From: Michael Eastham
Sent: 11 December 2017 12:43
To: Planning.Responses
Subject: FW: Land at Pollards Nursery, Barnham

I have read Noise Assessment for Proposed Residential Development at Lake Lane, Barnham (Report No. JAE9392-REPT1-R5), dated 30 October 2017. Could you ask the applicant to reply to the following points please?

Figure 2: Façade Treatment Plan (for Approved Scheme Ref: REDR140932SL01P11)

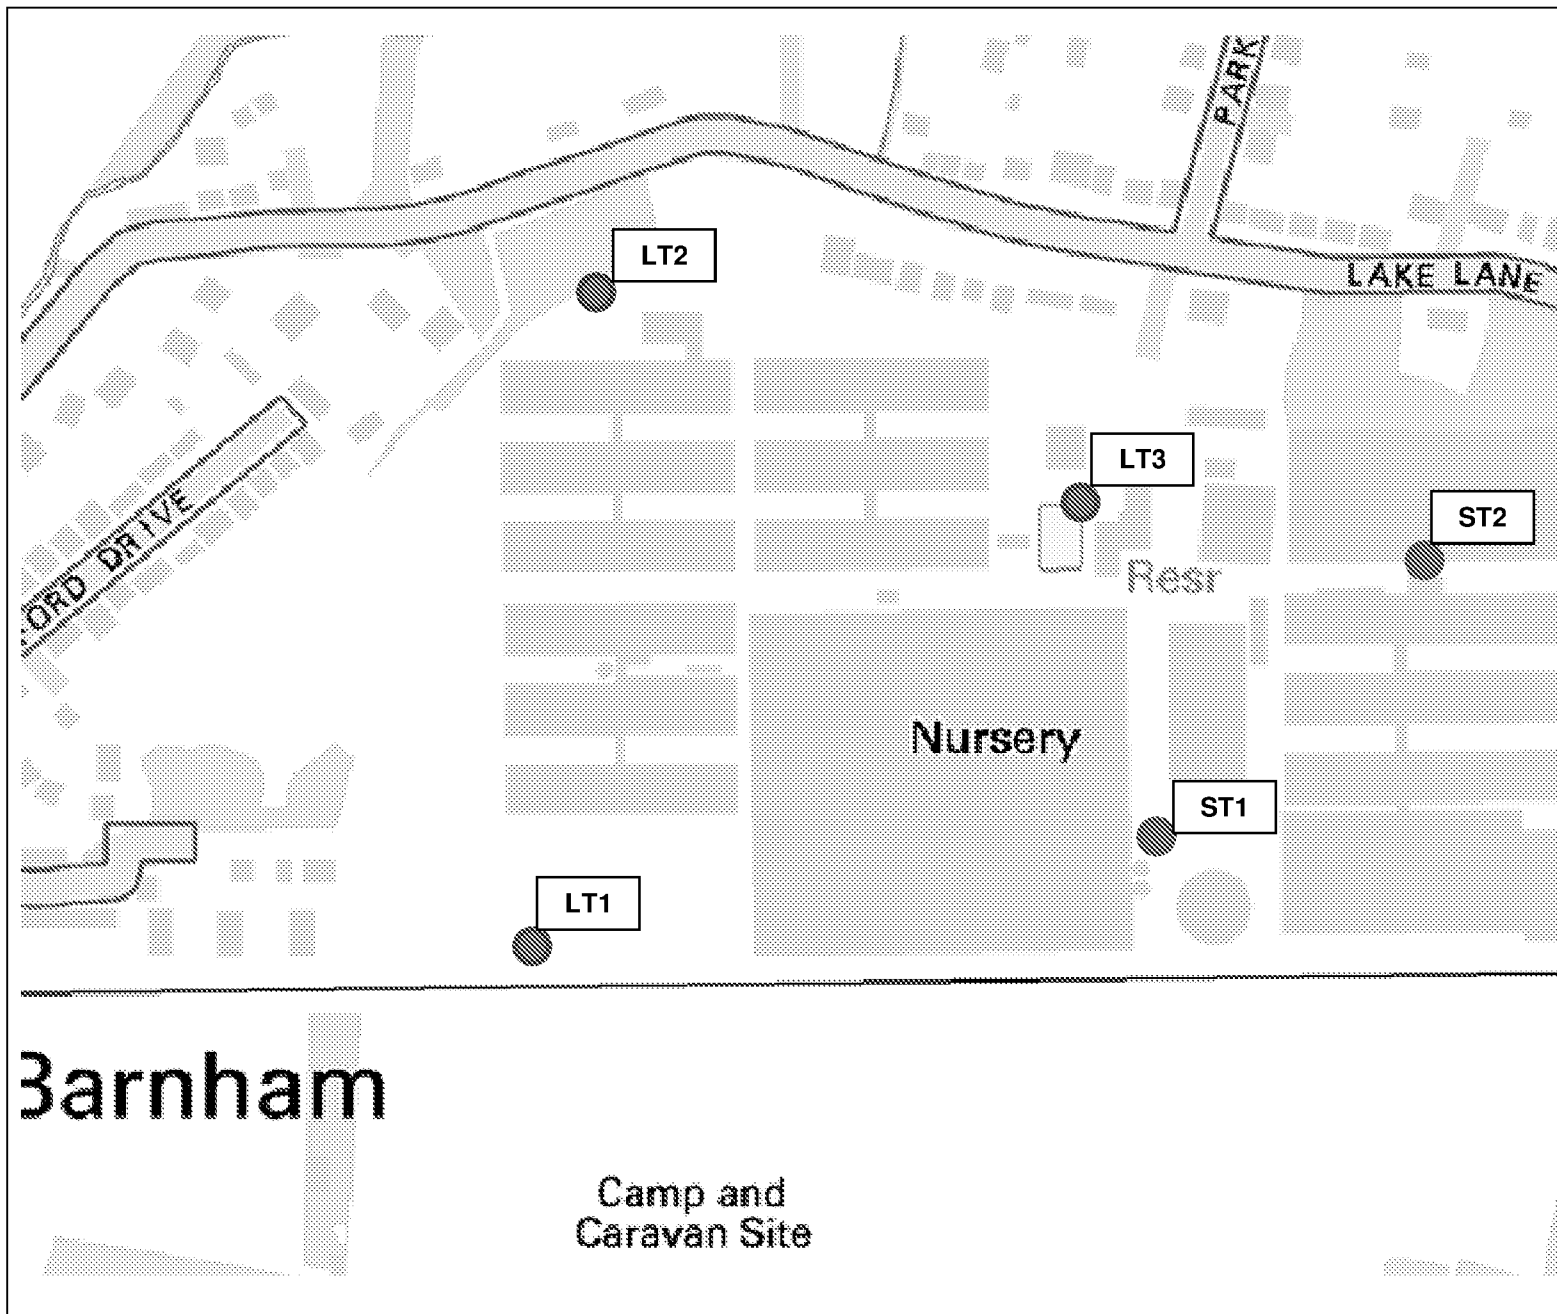
1. Is point LT2 actually on the northern boundary of the site? I am aware that the site layout has changed over time and I'm not sure that I've been looking at the most recent layout.

6. The report does not actually confirm that all dwellings are at least 15m from the boundary fence with the railway. Are they? Please could this be confirmed?

1. Based on the site layout drawing we have from Thrive Architects (ref: Job No. RED140932 Drawing No. SL.01 Rev. P11 – attached for reference) LT2 was located within a few metres of the northern boundary of the site. I understand that the most recent update to the site boundaries have not changed substantially, therefore we can confirm that was located approximately on the northern boundary of the site.

5. Covered in point 4.
6. Can you review and confirm that all dwellings are at least 15 m from the boundary fence with the railway as this is a design issue.
